**PLAN REVIEW SHEET**

**Petition #: RZP 2022-107**

**Address: 1428 Parkwood Ave.**

**Request: UR-2 (CD)**

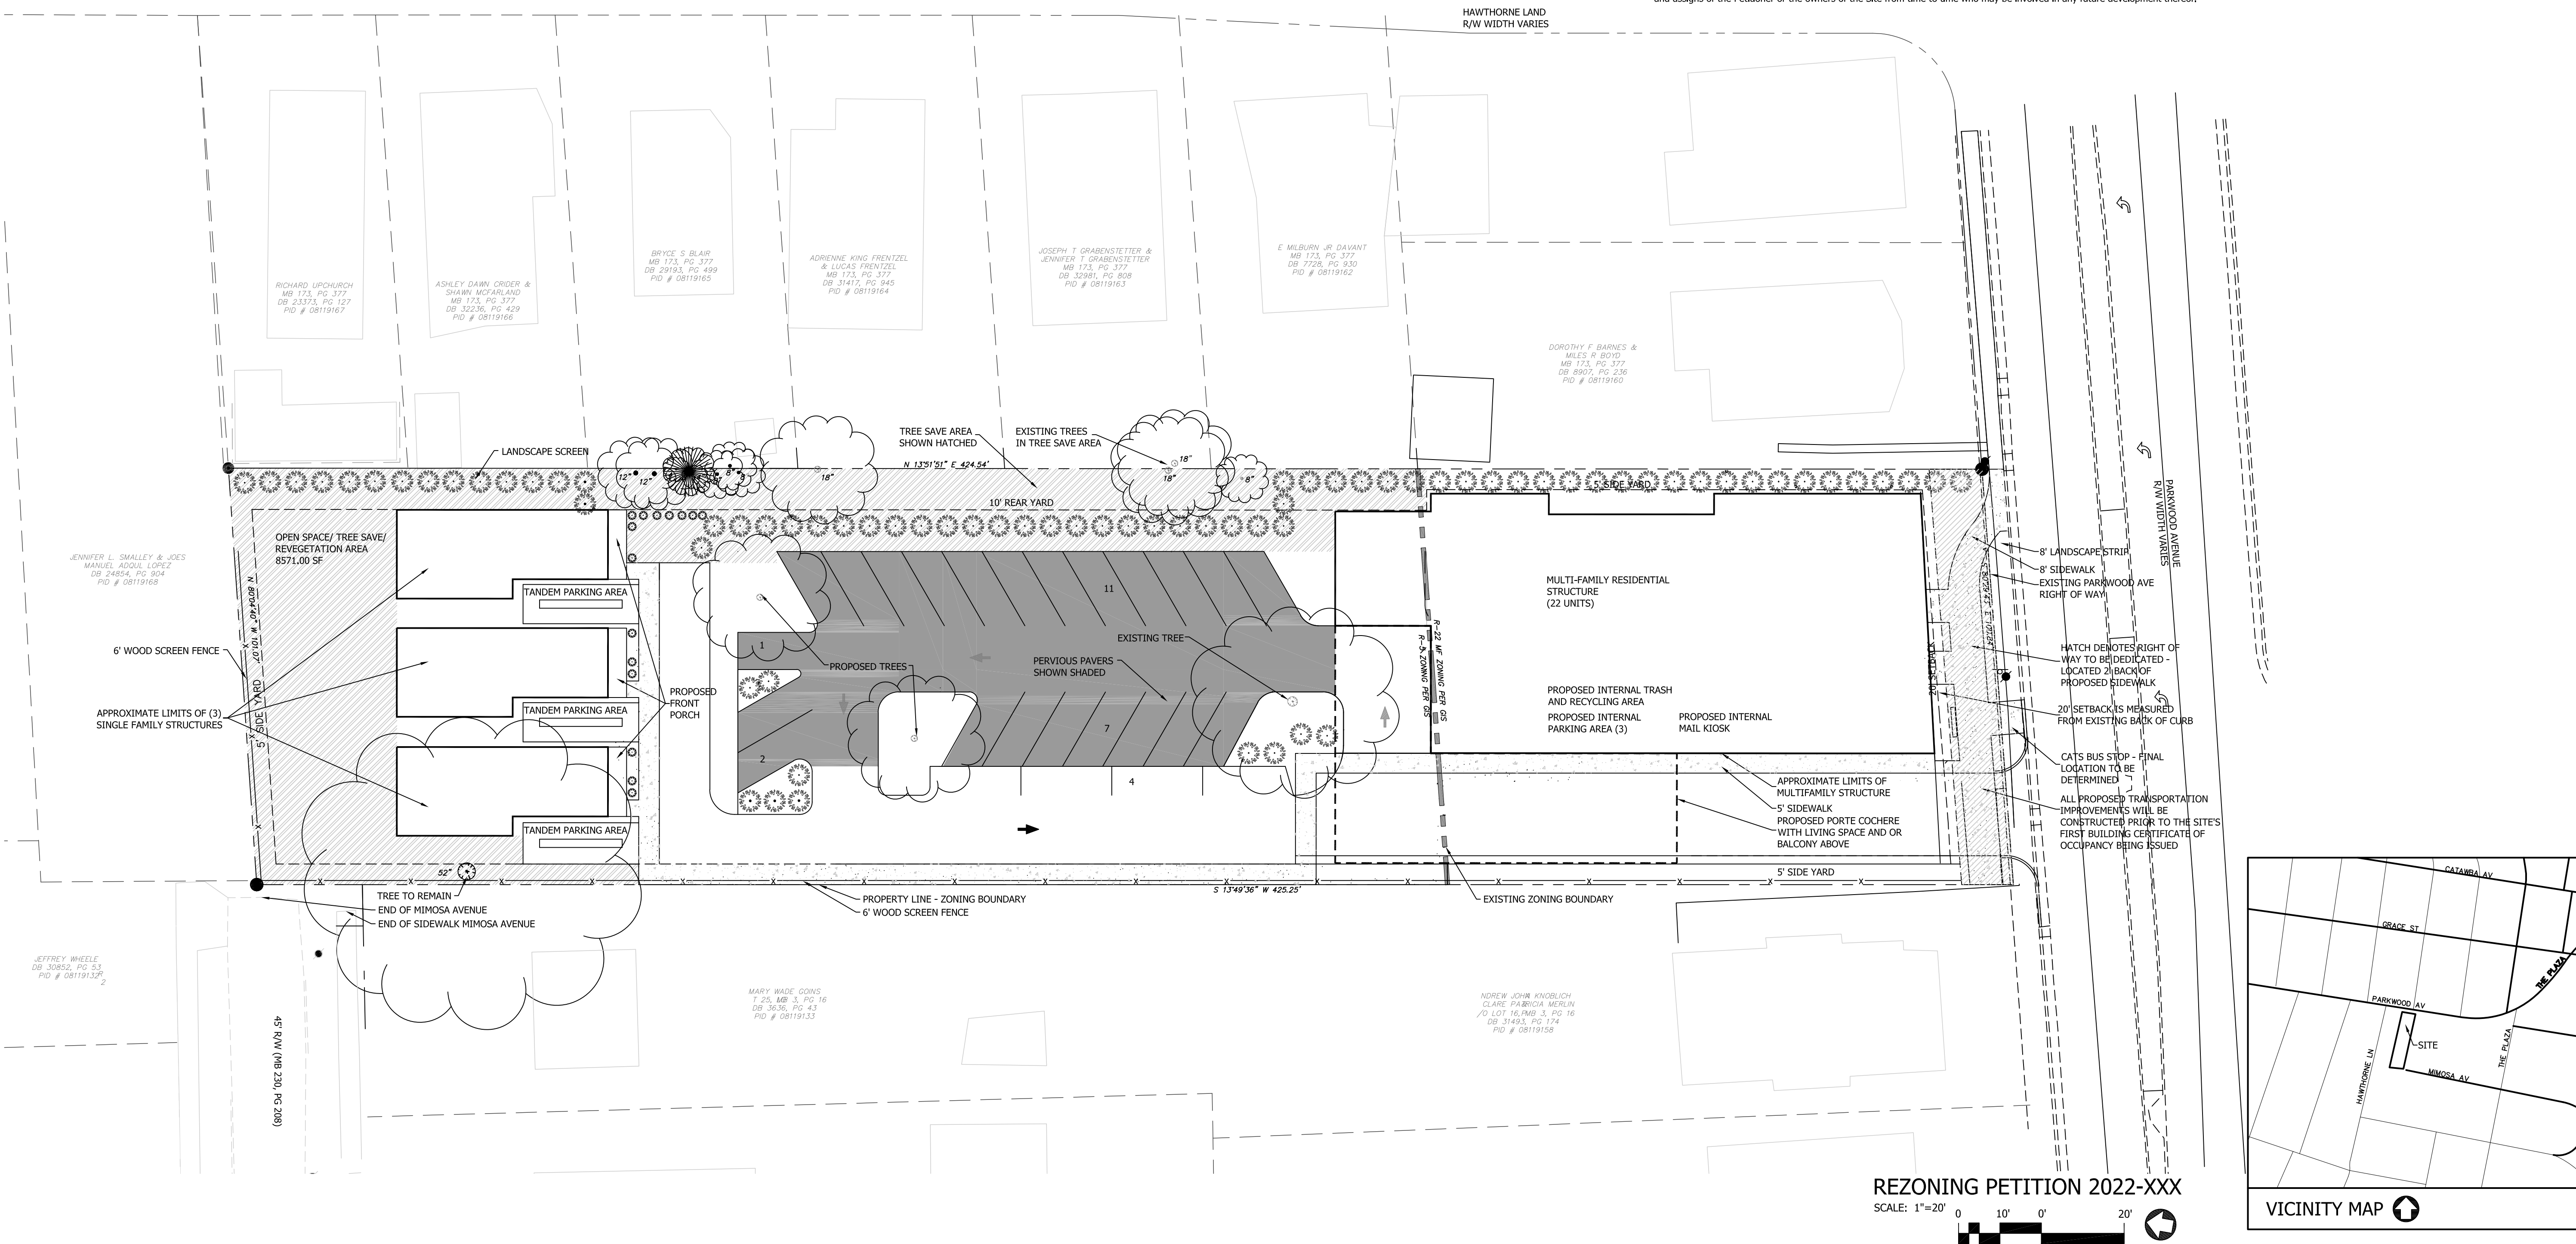
The site is located on CATS local bus route #4 along Parkwood Avenue. CATS requests the construction of ADA compliant bus stop type 60.01B. The final location will be determined during the Land Development plan review process.
